The Planning Act 2008

Section 55 Acceptance of Applications*

Section 55 Acceptance of Applications

Section 55 Application Checklist¹

Drawing file: EN010091 / EN010091-000985-2.6B Indicative Gas Receiving Facility and Gas Compressor Elevations D5.pdf

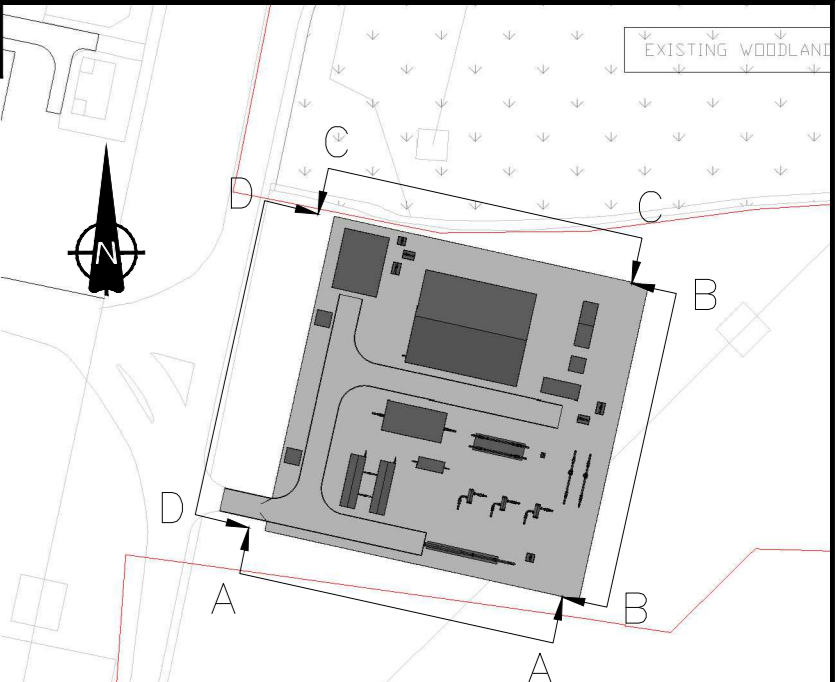
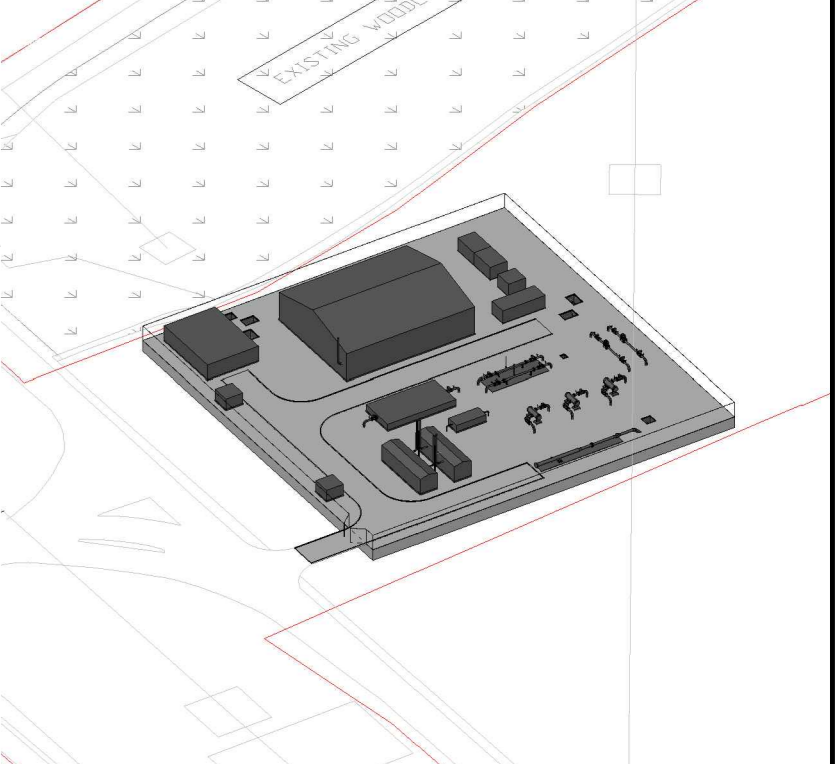
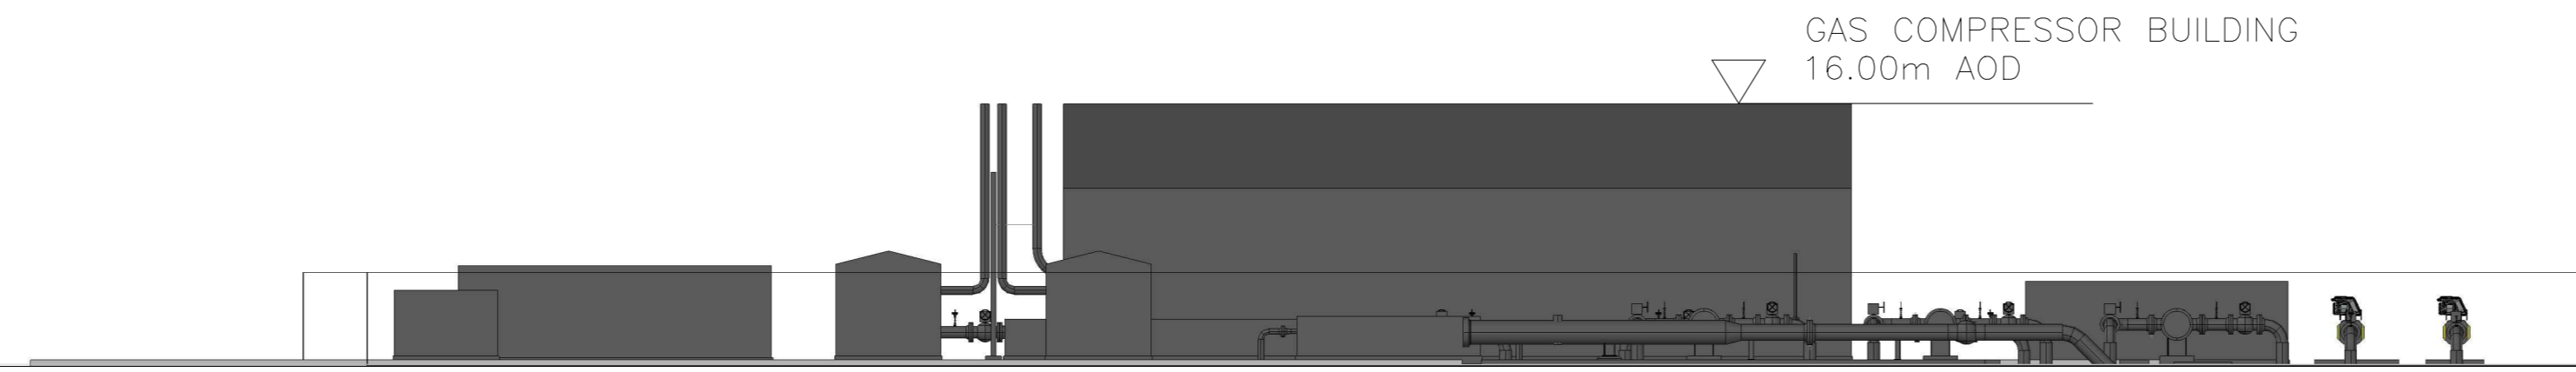
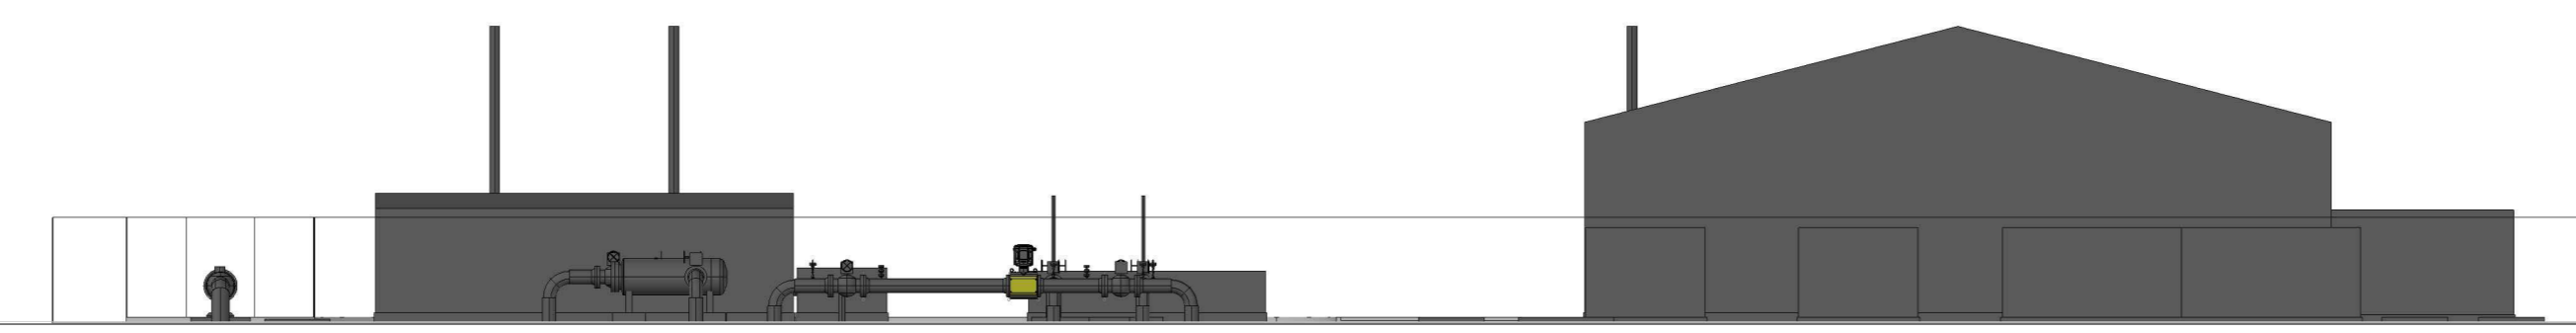
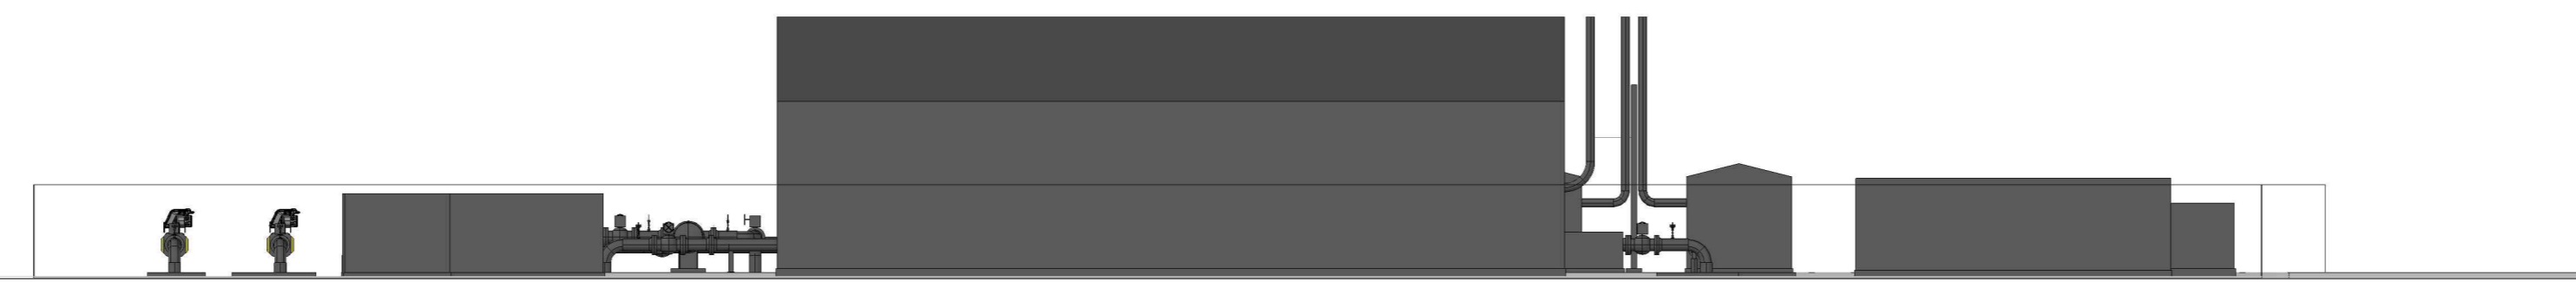
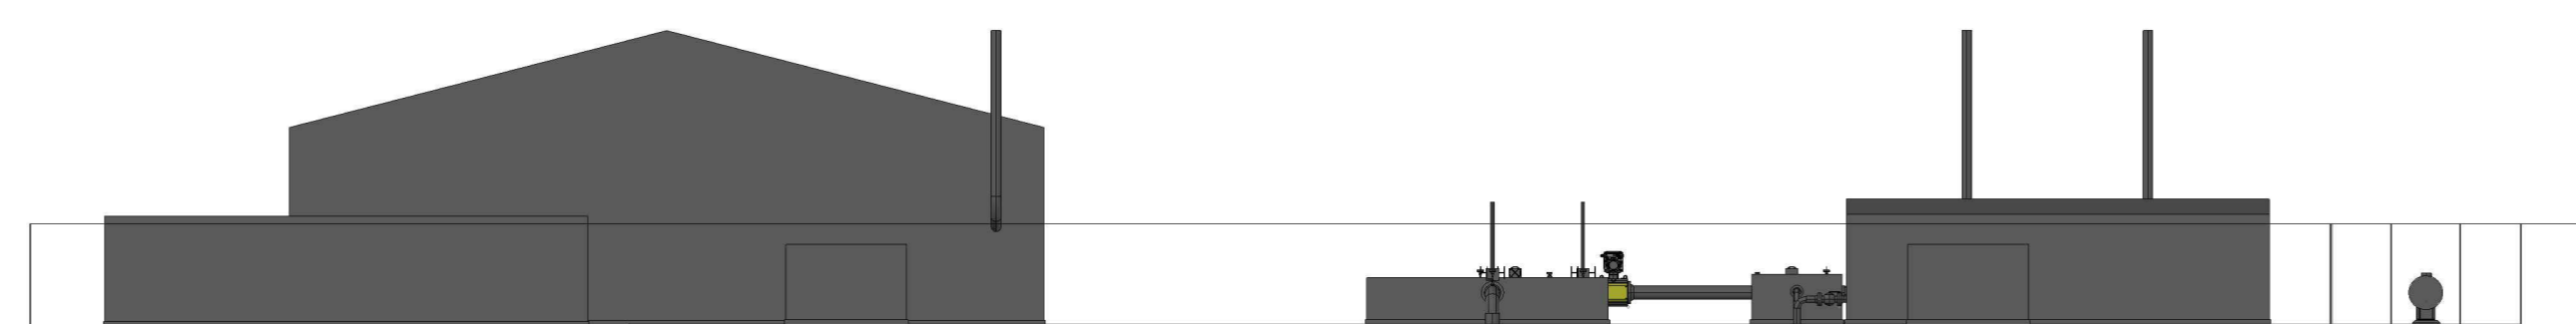
The Indicative Above Ground Installation (AGI) Elevations drawing (**Document 2.6C**) depicts a building and a nearby satellite dish (shown on the plan view to the far east of the plot and also on the isometric view). These are also shown clearly to the far right of the South Elevation drawing and the far left of the North Elevation drawing, however when comparing this to the Indicative Plant Layout plans for the AGI (sheet 8), for both the 'one unit option' and the 'two unit option' (Documents 2.5A and 2.5B) this same building and satellite dish are not illustrated.
